54 Commercial St. - permit 2017-00677 temporary structure for public restrooms

I have completed my initial zoning review of the permit. I need some more information before I can sign off for zoning.

# 1) 40' Bathroom Container

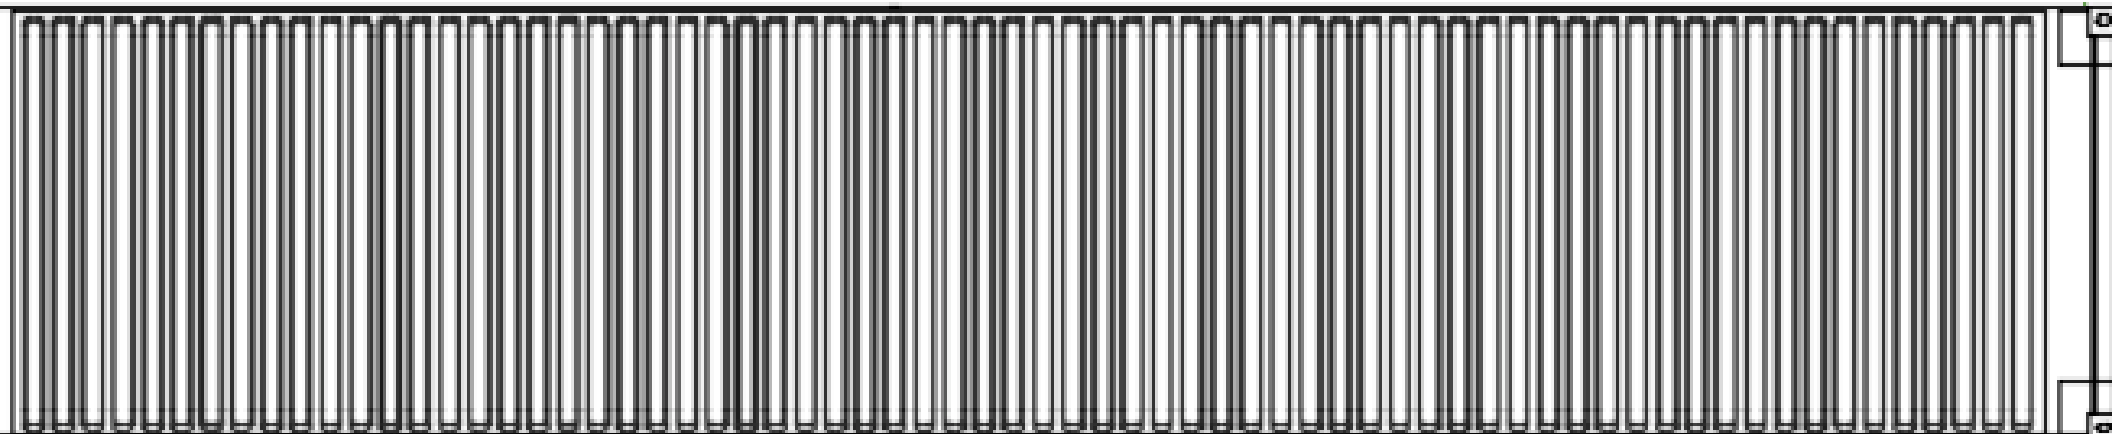
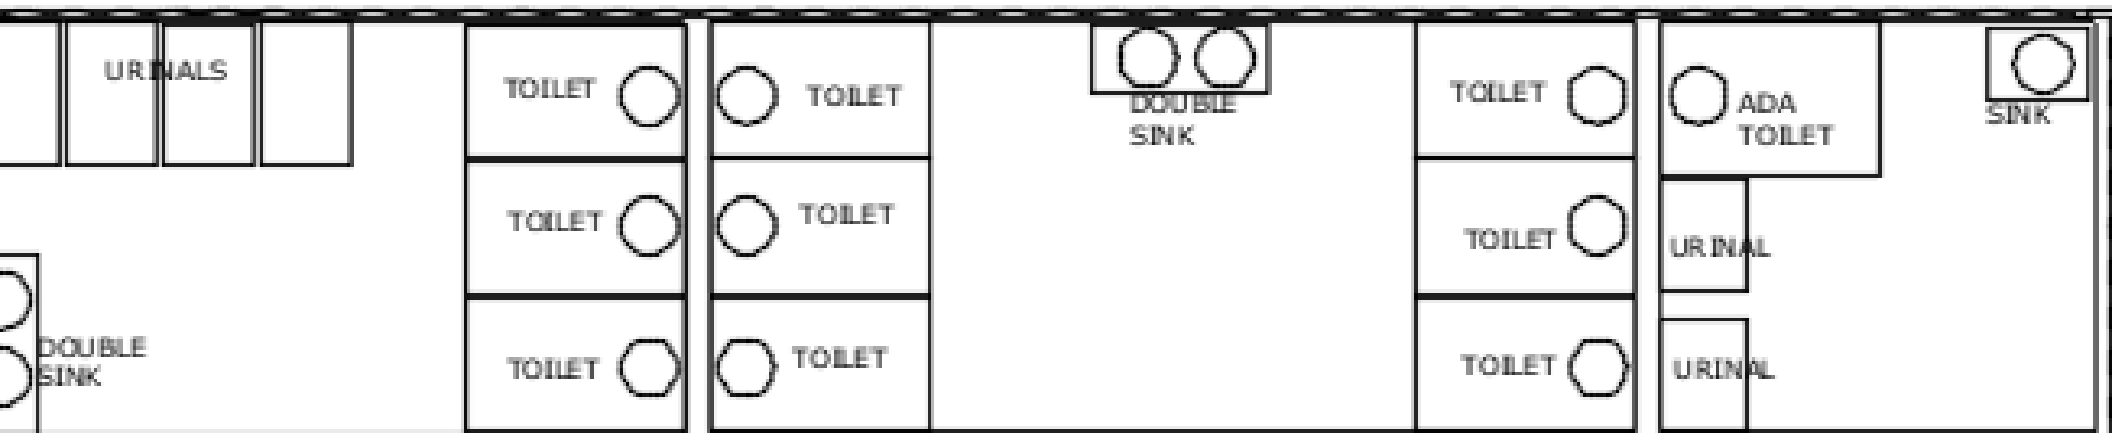
1. I need to know the dimensions of the shipping container. The application says that it is 40' long but how wide is it and how tall is it?
2. What is the starting date and the ending date for the 2017 concert season?

3. You need to provide details on how the shipping container will be anchored to the pier.
4. The pier is located in the Special Flood Hazard Area (SFHA) as shown on Panel 14 of the Flood Insurance Rate Map (FIRM) Revised to Reflect LOMR Effective: November 9, 2012. The proposed location of the structure appears to be in Zone A2 with an elevation of 11', but this needs to be confirmed with a more accurate site plan. Although this structure is temporary, under sections 14- 450.5, 14-450.6 and 14-450.8 all development within the SFHA must submit flood hazard development permits that are reviewed by the zoning division. You need to submit the Flood Hazard Development Application and the Flood Hazard Development Permit for Minor Development (attached). As a temporary structure, you also must submit an Emergency Action Plan that will be implemented when there is the threat of a flood. This plan must designate the person who will be responsible for executing it, it must outline a timeline of when the decision will be made to remove the structure and a complete plan that details how the structure will be detached from the anchoring system, disconnected from the water and sewer line, how these two lines will be capped and how the structure will be physically removed from the flood area. .

40' x 7'8" x 8'5.5"

Containers are not anchored to the pier. Coming in at 10-tons, this container is self ballasted.

CITY OF
PORTLAND
230051

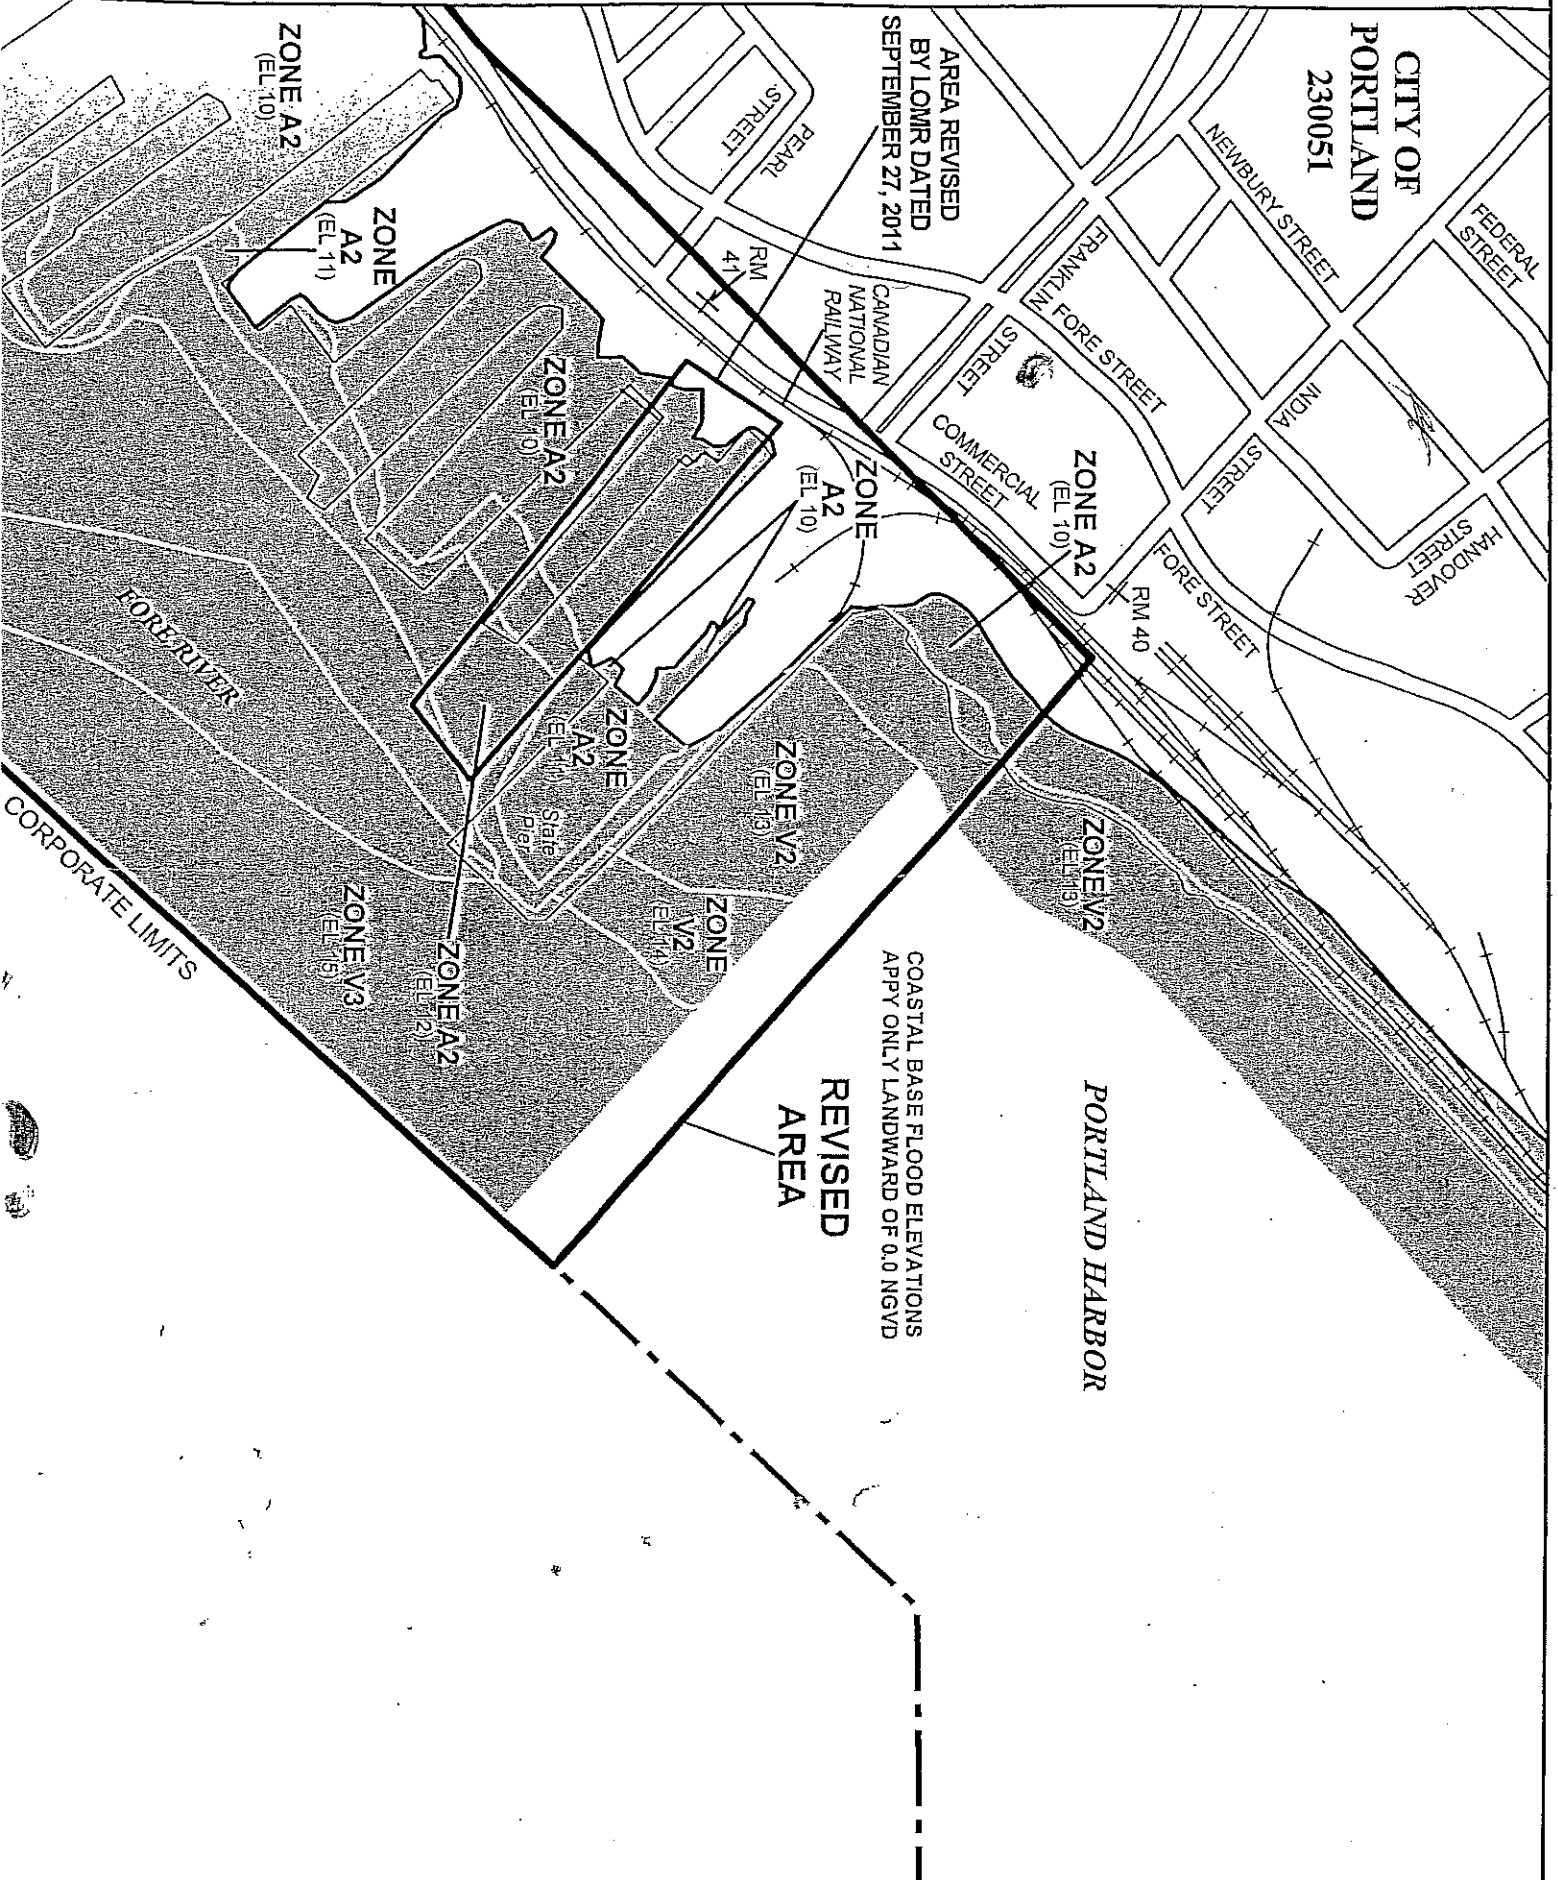
4. The pier is located in the Special Flood Hazard Area (SFHA) as shown on Panel 14 of the Flood Insurance Rate Map (FIRM) Revised to Reflect LOMR Effective: November 9, 2012. The proposed location of the structure appears to be in Zone A2 with an elevation of 11', but this needs to be confirmed with a more accurate site plan. Although this structure is temporary, under sections 14- 450.5, 14-450.6 and 14-450.8 all development within the SFHA must submit flood hazard development permits that are reviewed by the zoning division. You need to submit the Flood Hazard Development Application and the Flood Hazard Development Permit for Minor Development (attached). As a temporary structure, you also must submit an Emergency Action Plan that will be implemented when there is the threat of a flood. This plan must designate the person who will be responsible for executing it, it must outline a timeline of when the decision will be made to remove the structure and a complete plan that details how the structure will be detached from the anchoring system, disconnected from the water and sewer line, how these two lines will be capped and how the structure will be physically removed from the flood area.
